Your Ref: OWPC16541
Our Ref: FP/268/17/PL 26-10-2017
Please ask for:
Richard Temple

Detached 9No. bedroom annexe for Beachcroft Hotel with 9No. car parking spaces.
Boat Pound between Greenock Villa & The Gunpoint Clyde Road Felpham

Thank you for your internet representation made on 8th December 2017 which has been recorded as '**an objection**' with the comments as follows:

PROJECT	Gull Point Suites - On the Beach	DATE	20/09/17
TITLE	Roof Plan	DRG NO	IBA/480/10
SCALE	1 : 50	REVISIONS

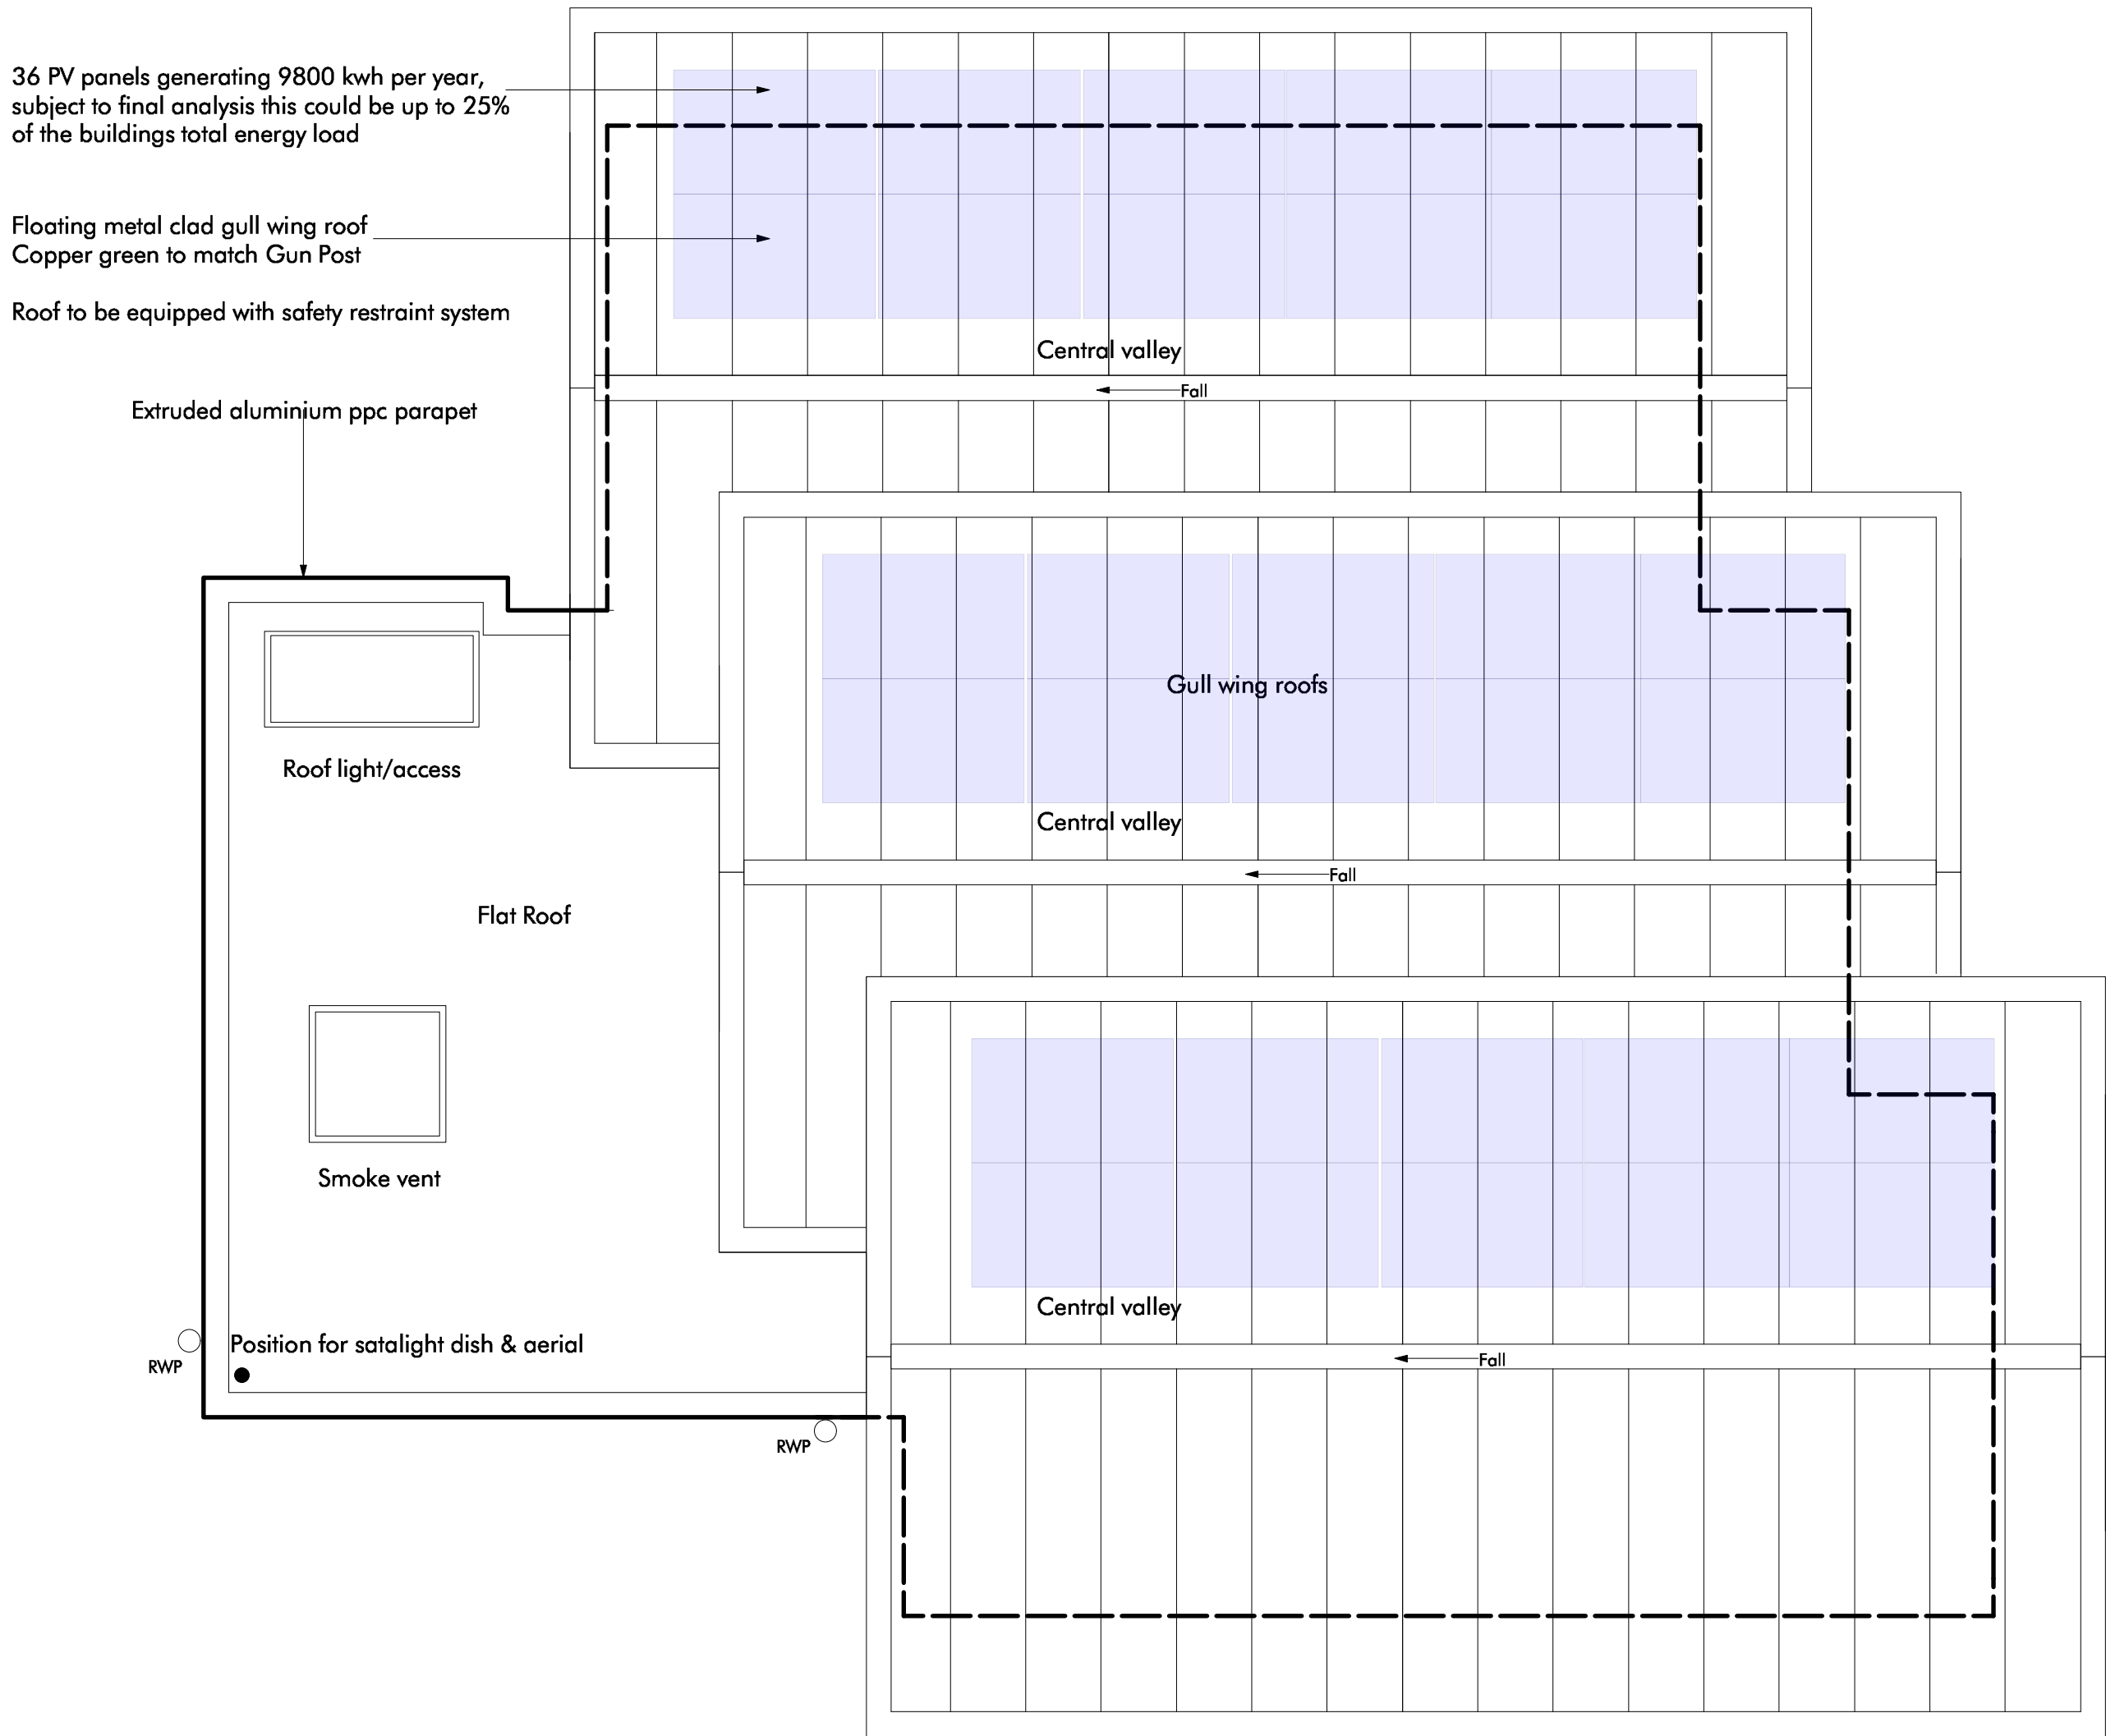
The Gull Wing roof is a major folly in the face of the Winter Gales that batter the Headland. Designs and materials in Seaside areas must be solid and weatherproof, tried and tested and proven to withstand the ravages of Tide and Time. If not, they will soon rot. Glass frontage constantly exposed to sea water, battered by salt laden coastal wind and

PROJECT Gull Point Suites - On the Beach
TITLE Typical Sections
SCALE 1 : 100
DATE 20/09/17
DRG NO IBA/480/09
REVISIONS

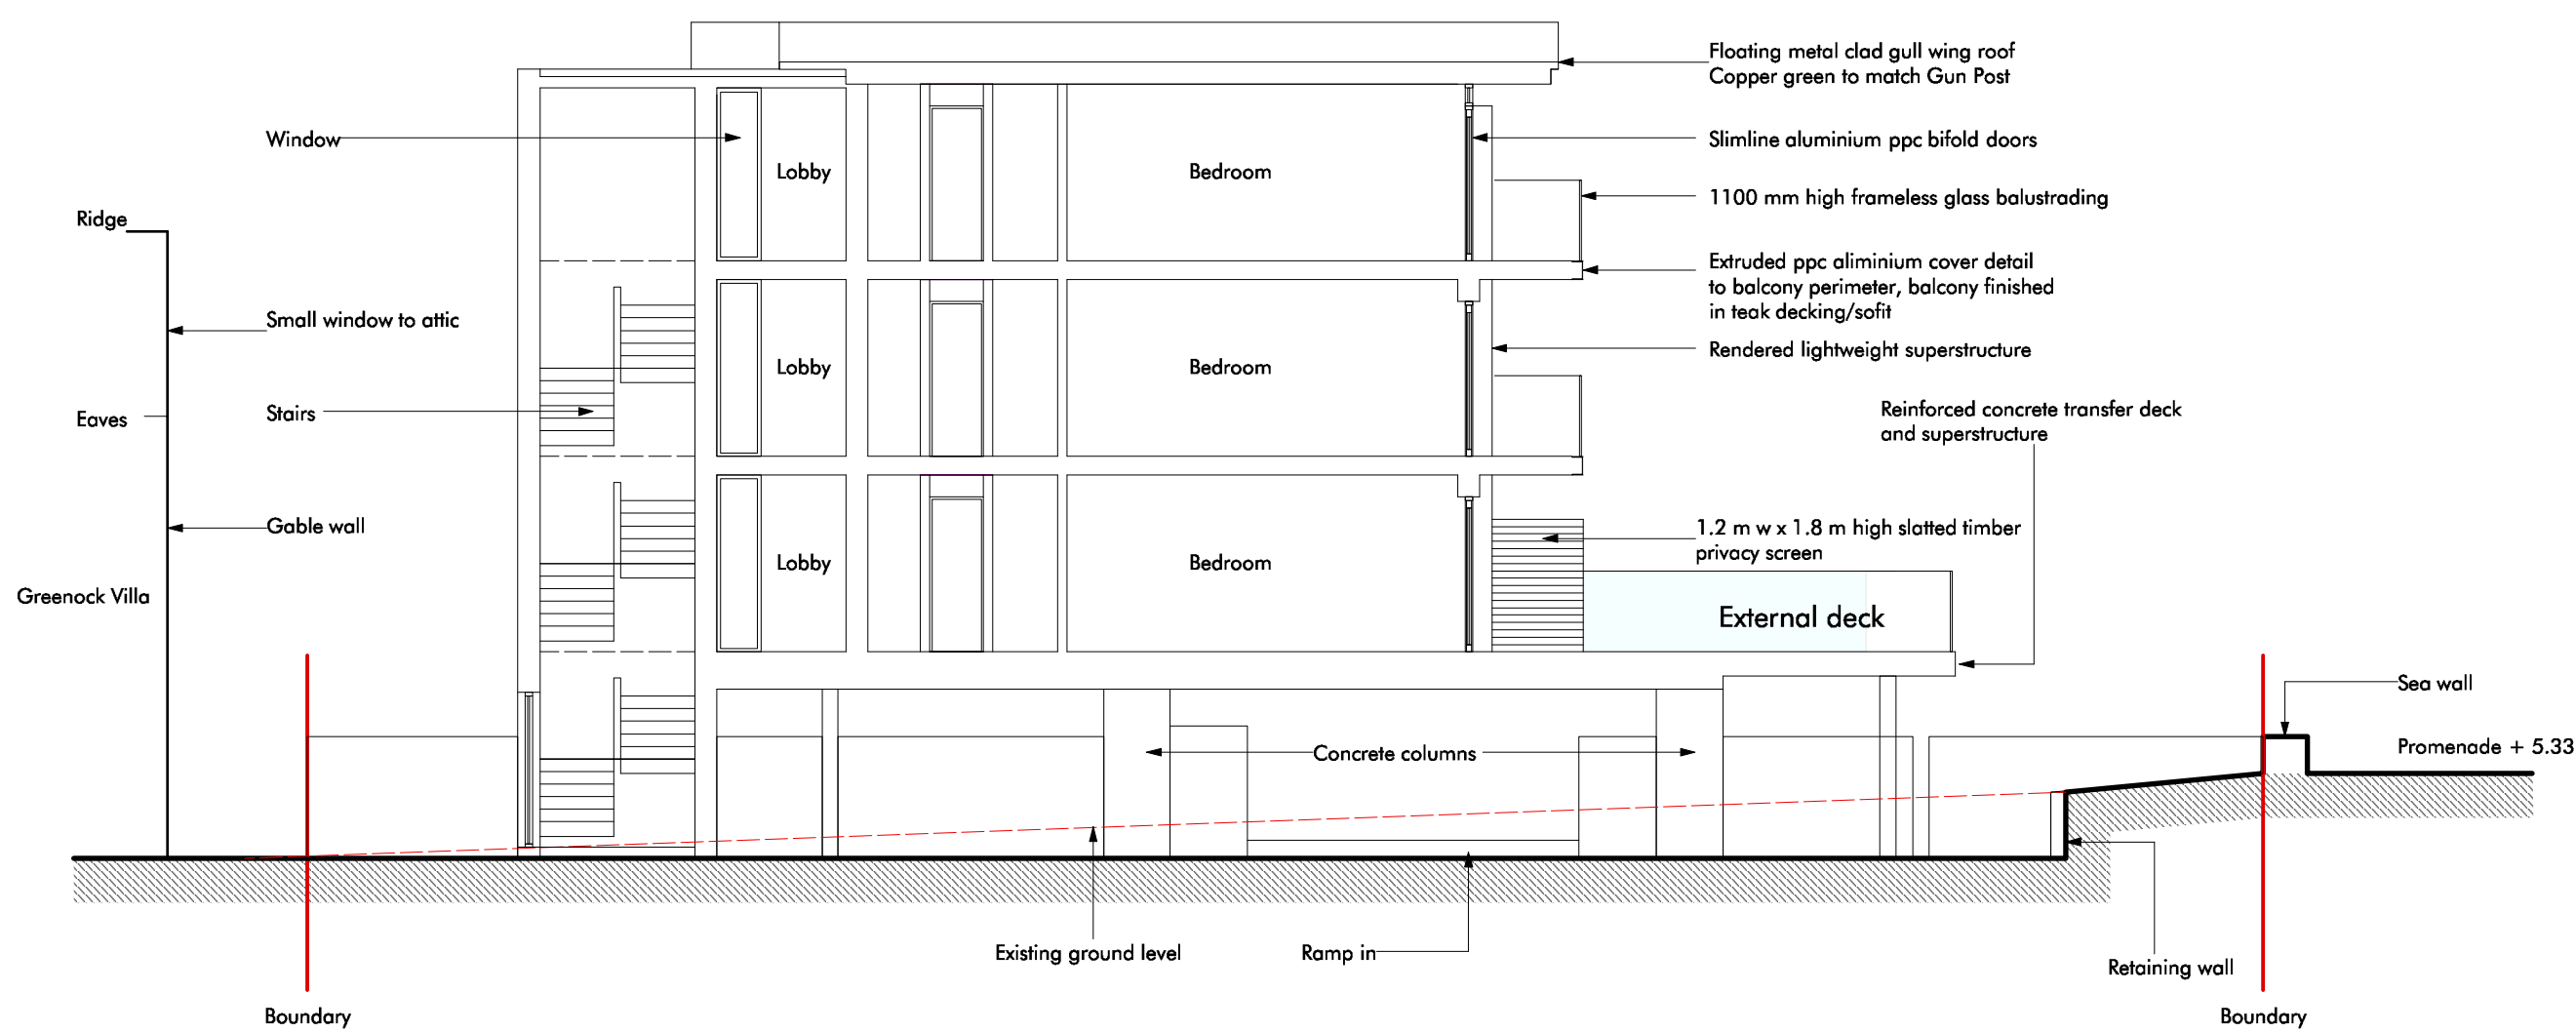
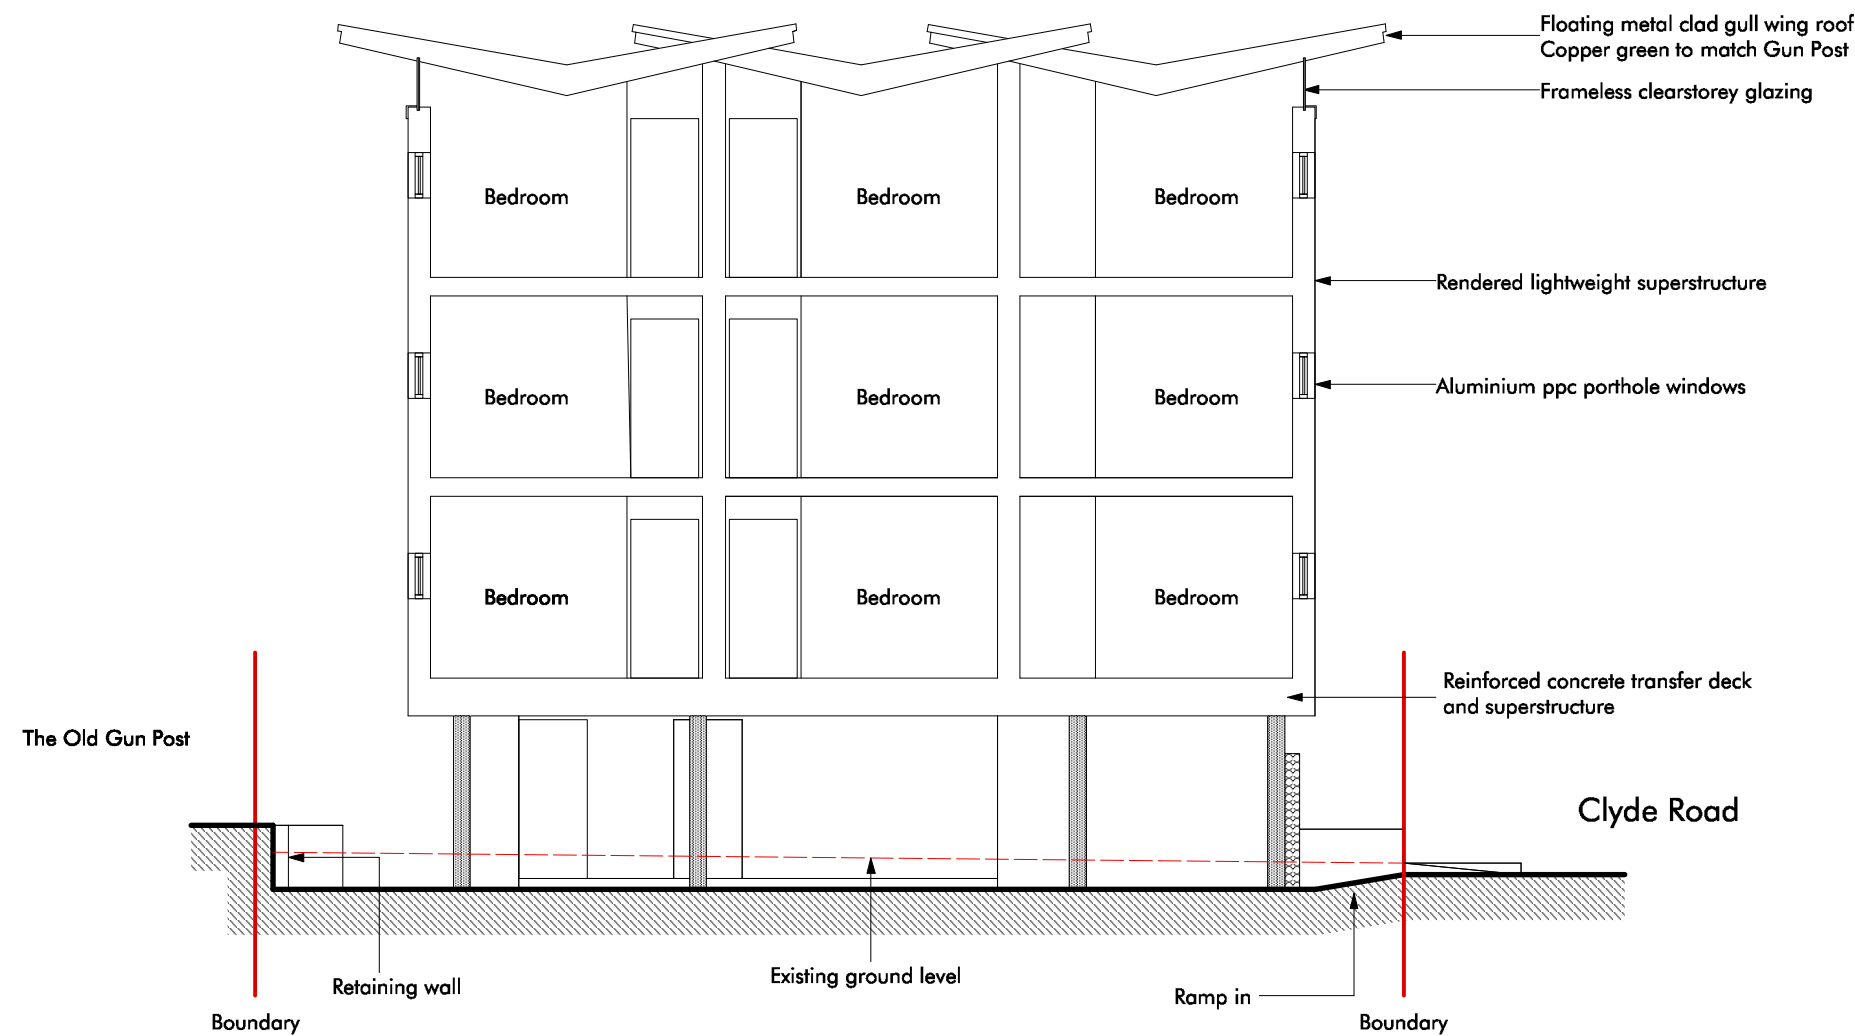
The proposed 4 storey building (3 plus the lower parking floor) is way too large for the allocated space. Almost a storey higher than neighbouring properties and on the very edge of the Promenade. It would totally dominate the Victorian buildings on Clyde Road and the Gun Post itself. The promenade is quite narrow there and passage is constricted by the corner. The formidable mass of a glass edifice looming above the promenade would be overwhelming, unsightly, and extremely intimidating.
